DECISION DELEGATED TO HEAD OF PLANNING

Application No:	H17-0765-26	Applicant:	Mr F Hahn
Proposal:	Details of contamination of land or pollution of controlled waters, existing and proposed site levels, proposed floor levels, hard surfaced areas, garden/amenity areas, foul and surface water disposal, proposed boundary treatments and external materials (Conditions 3, 6, 7, 8 and 10 of H17-0880-25)		
Location:	7 The Reservoir Surfleet Spalding		
Terminal Date:	7th October 2026

PROPOSED ELEVATIONS

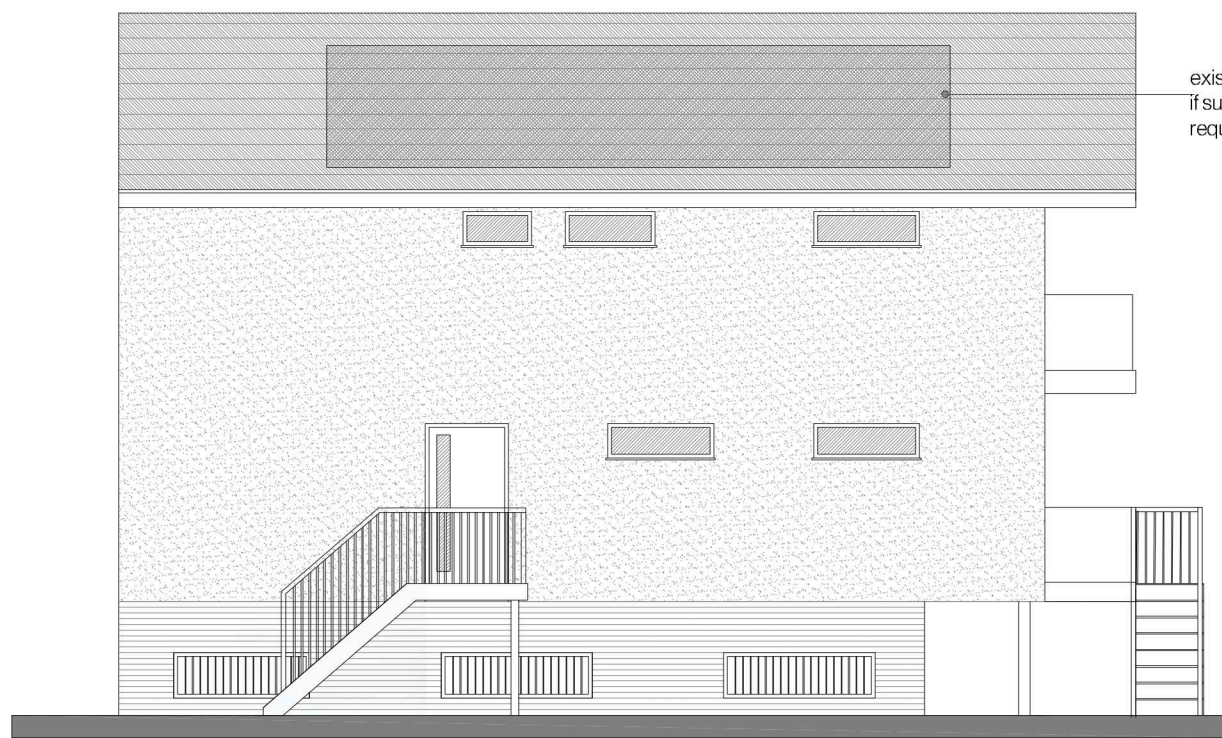
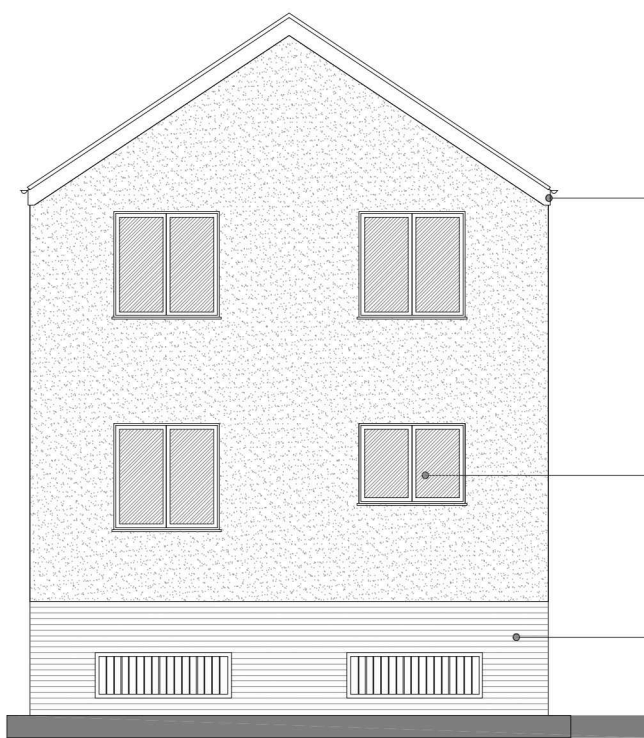
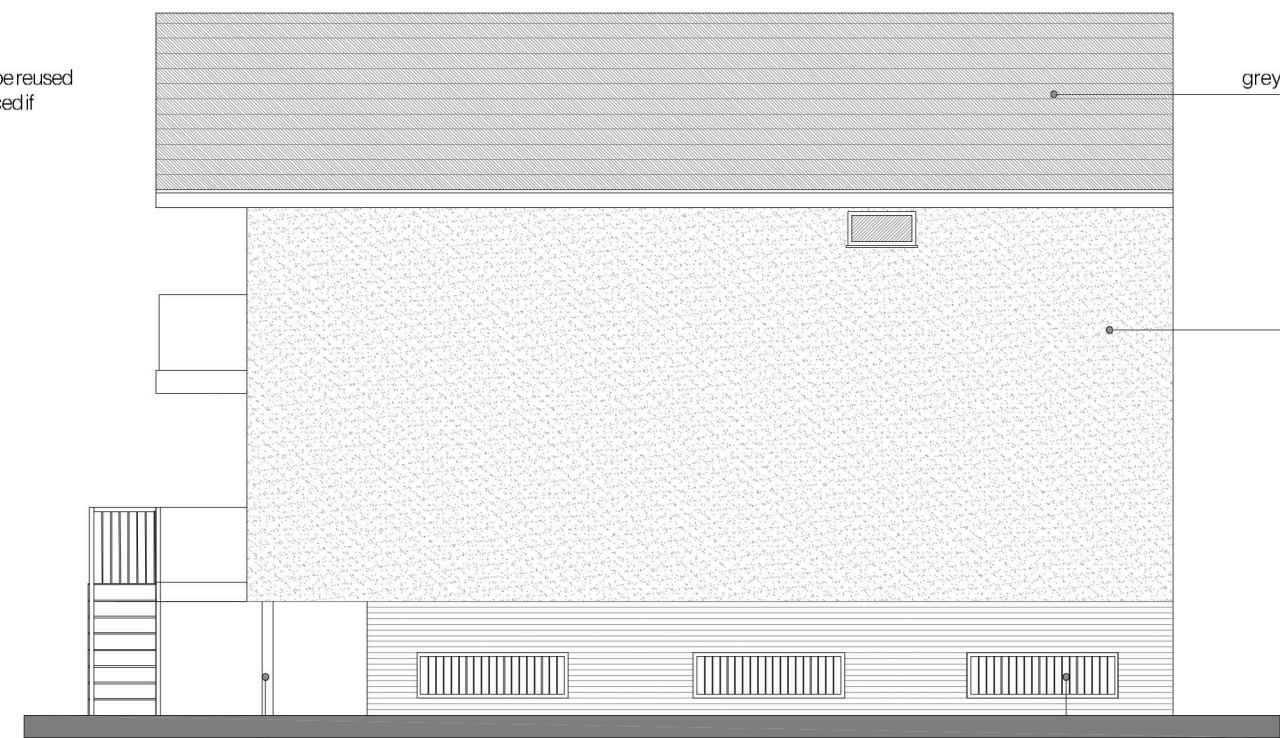
The external materials are set out on submitted plan 25/680/PA/004F. The external materials include K Rend white render walls, a grey concrete slate roof and grey engineering bricks. The details are considered to be acceptable and as such, condition 10 can be discharged.

PROPOSED BLOCK PLAN

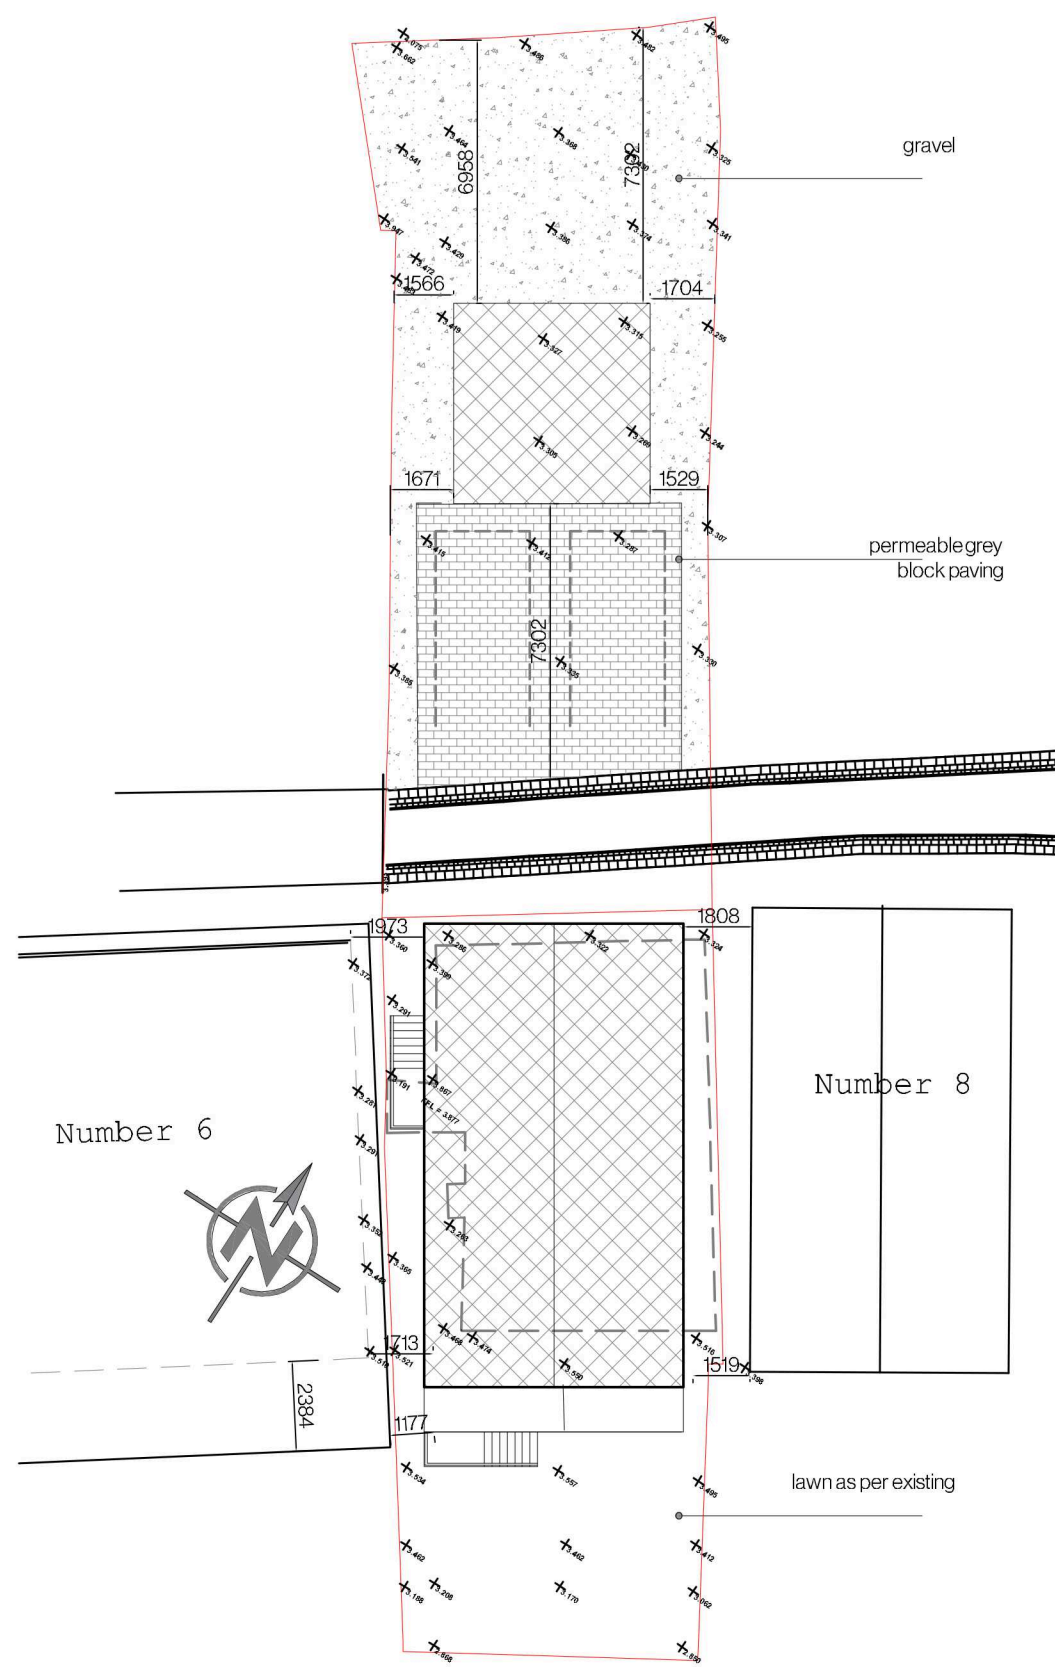
The site levels are shown on submitted plan 25/680/PA/004F and as set out within the cover letter, the site levels are not proposed to be raised. The site levels would have an acceptable visual and amenity impact and as such, condition 6 can be discharged.

According to submitted plan 25/680/PA/004F the existing surface water system will be retained which includes permeable surfaces throughout the site except where the dwelling and the garage are proposed. As part of the determination of application H17-0880-25, it was established that the impermeable area within the site should not increase as a result of the proposals. As such, the proposals should not result in a worse impact in drainage terms than the existing development within the site.

No new boundary treatments are proposed and as such, condition 8 can be discharged.
